**Please ask for** Theresa Folpp  
**Direct** 02 6549 3700  
**Our reference** CM 25/36788

18 July 2025

**Maxwell Underground Mine MOD3 – Muswellbrook Shire Council comments on the Modification Report**

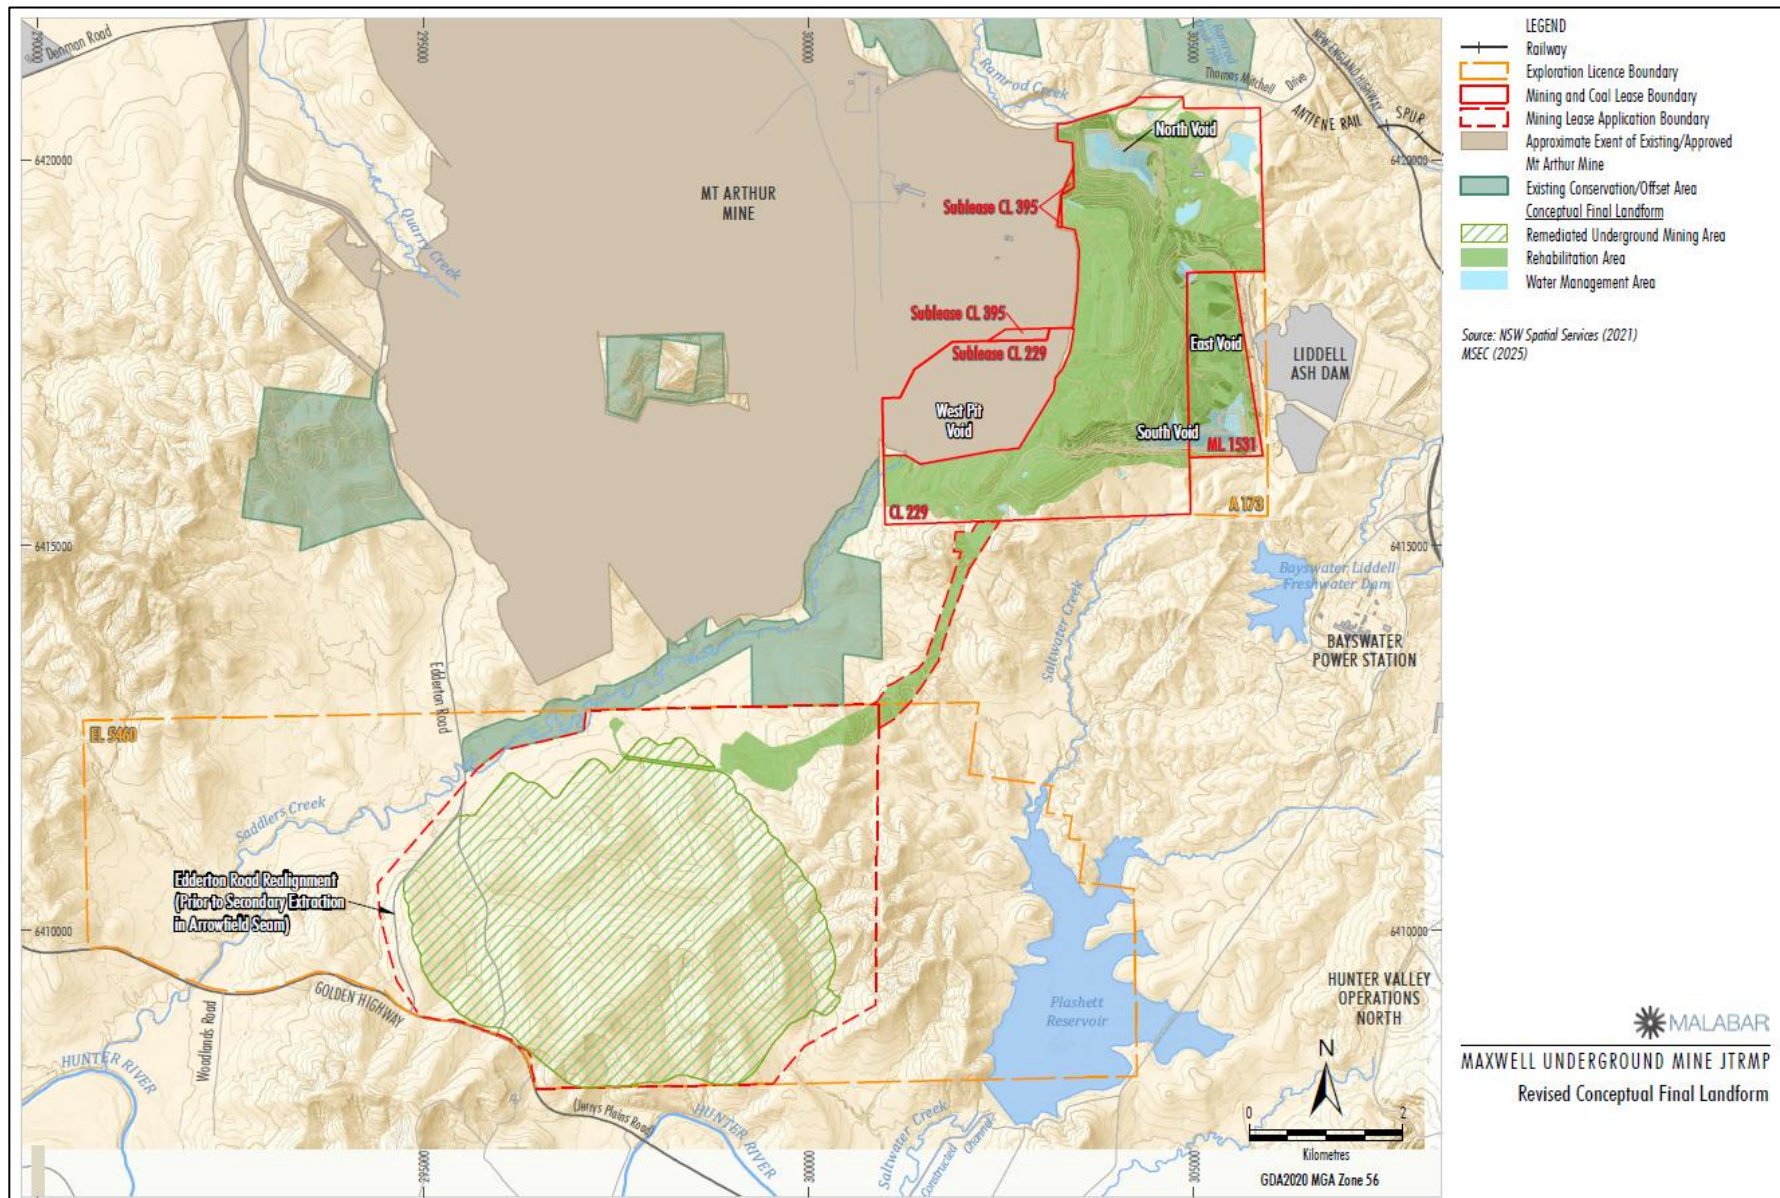
The size and shape of the North Void, as shown in the Revised Final Landform, does not appear to be reduced compared to the currently approved final landform.

3. As noted in Section 6.1.1 of the Modification Report, *‘WRM (2025) has assumed that a channel will be constructed to link the East and South Voids at 175 mAHD’*. An indicative location of the channel should be shown in the Final Landform and if it is required, it should be designed in a way that appears more natural and less engineered.
